**KIRKLEES METROPOLITAN COUNCIL
INVESTMENT & REGENERATION SERVICE**

Reference No:	2023/62/90464/E
Site Address:	126, Gomersal Lane, Gomersal, Cleckheaton, BD19 4JQ
Description:	Erection of extensions to form two-storey dwelling
Recommending Officer:	Jennifer Booth

DECISION - REFUSED

OFFICER REPORT

Proposed Floor Plans & Elevations
Date: JAN23
Designed: RF
Scale: As indicated
Drawn: RF
Drawing No: 23-004-02
Checked: JW
Revision: -

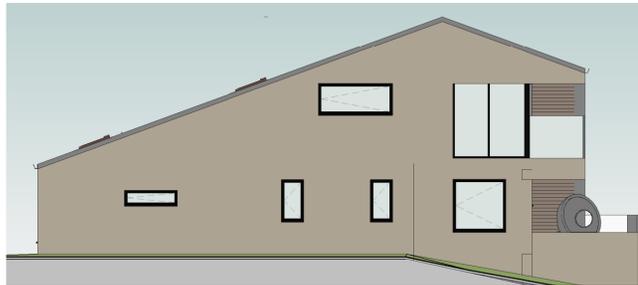
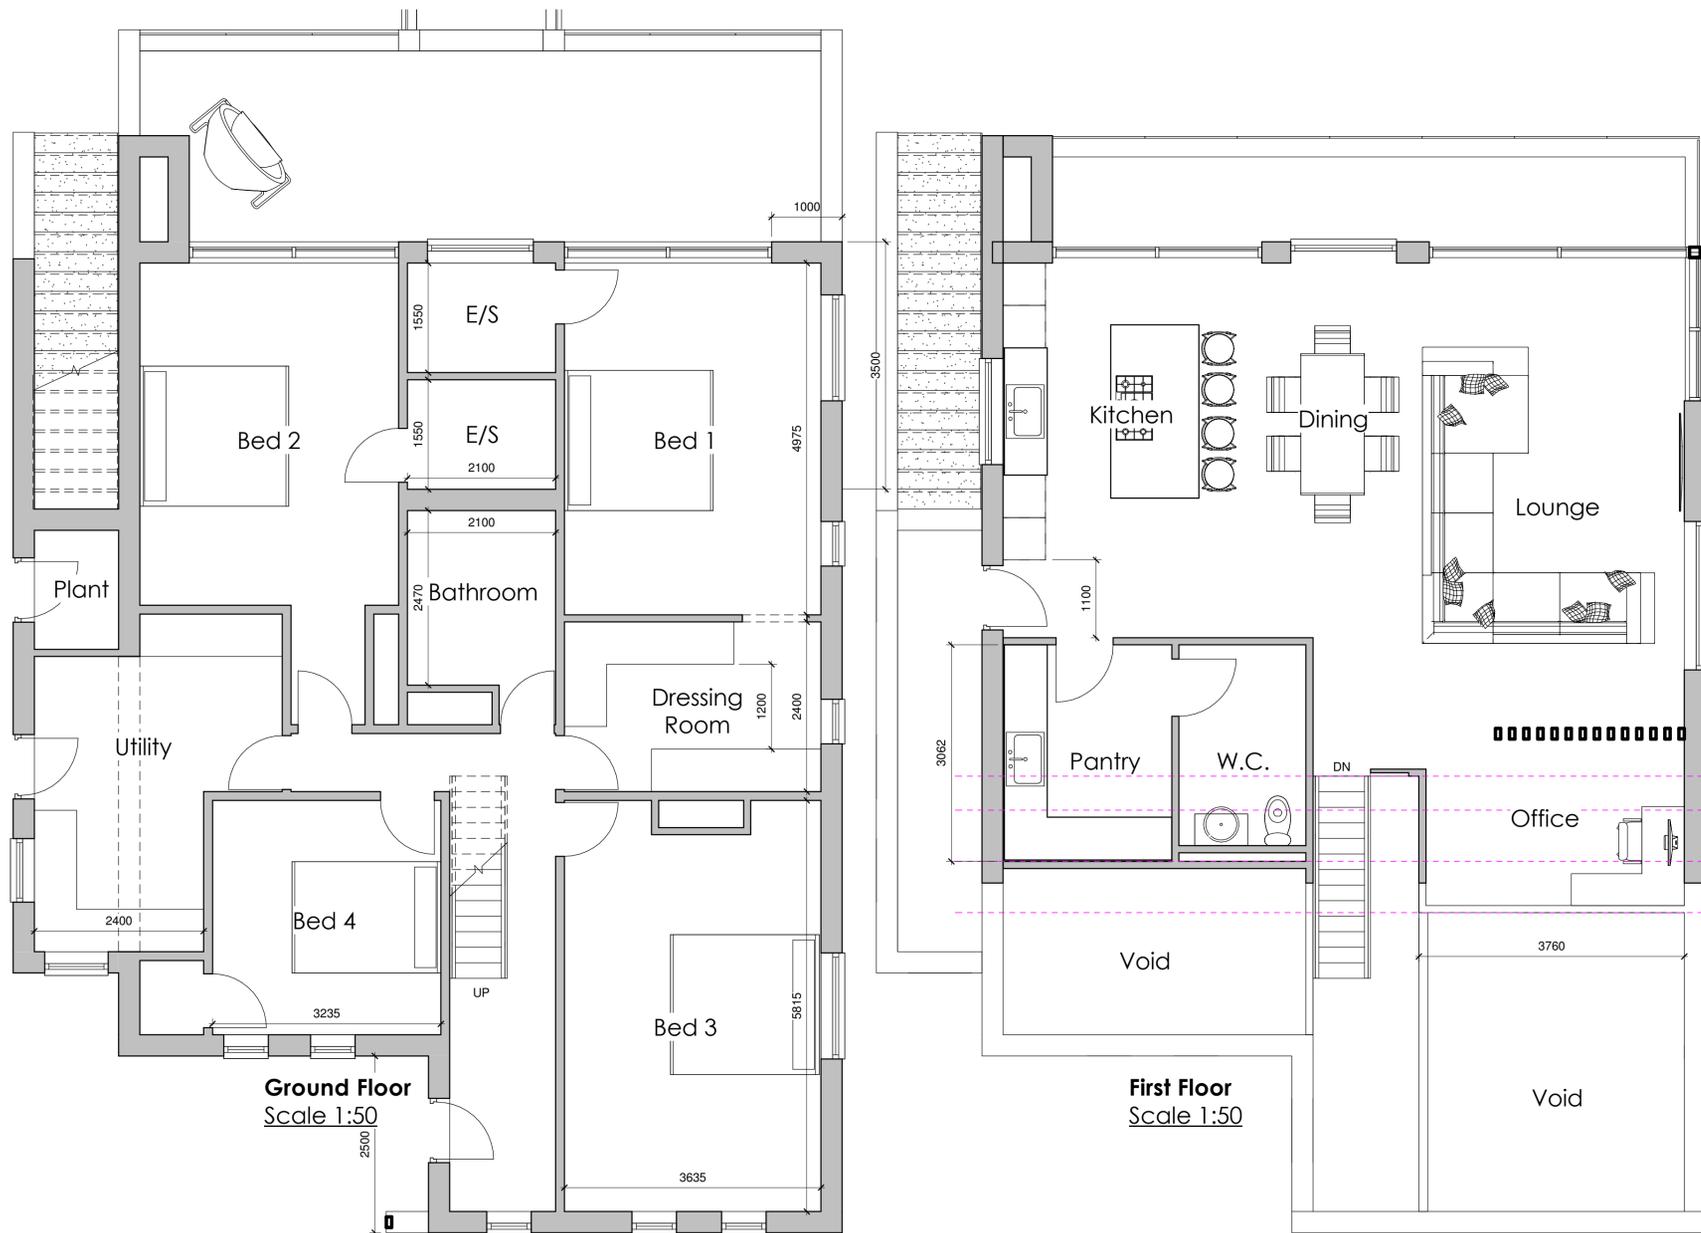
The works proposed include a single storey element to the front projecting 2.7m across part of the width of the dwelling (6.4m). The depth of the dwelling would be increased from 11.7m (including the sunroom) to 15.5m. The overall height of the dwelling would be increased from 5.8m to 7m with a single storey appearance from the front and two storey at the rear. The walls would be clad with stone.

The plans show the formation of a terrace on the ground level at the rear along with a recessed balcony at first floor with full enclosure on the boundary with the neighbouring dwelling.

The existing property is a modest, brick built bungalow with dormers, set in substantial grounds. The proposals would see a significant increase in the massing, extending forwards slightly and taking the height of the property upwards. Together with wholesale alterations to the fabric of the building replacing the brick exterior with stone and incorporating very modern fenestration with glazing features. It is noted that from the front of the property, the appearance is as a bungalow with a two storey appearance to the rear. Overall, the significant alteration to the property would not be subservient and the original house would no longer be recognisable.

Paragraph 4.4 of the House Extensions & Alterations SPD does allow for some contemporary design. However, it would have to be demonstrably appropriate for the site context and make a positive contribution to the wider area. In this instance, given the prominence of the site together with the surrounding development, the works would be inappropriate and incongruous, particularly with respect to the significant shift in the character of the dwelling. As such, whilst this property could potentially be extended, the design would have to be altered, the scale reduced and the materials amended. The current scheme is considered to be unacceptable in terms of visual amenity.

1. The proposed extensions and alterations, by reason of the design, scale, bulk and massing in addition to the change of materials for the dwelling, would not appear sympathetic or subservient to the host property, resulting in an incongruous form of development detrimental to the wider street scene and harmful to the Little Gomersal Conservation Area. The harm is considered to be less than substantial for which no public benefit has been demonstrated to outweigh the harm caused, contrary to the aims of paragraphs 199-202 of the National Planning Policy Framework (NPPF). It is therefore considered that the development proposed would not accord with the aims of Chapter 16 of the NPPF, Policies LP24 and LP35 of the Kirklees Local Plan or Key Design Principles 1-2 of the House Extensions and Alterations SPD.
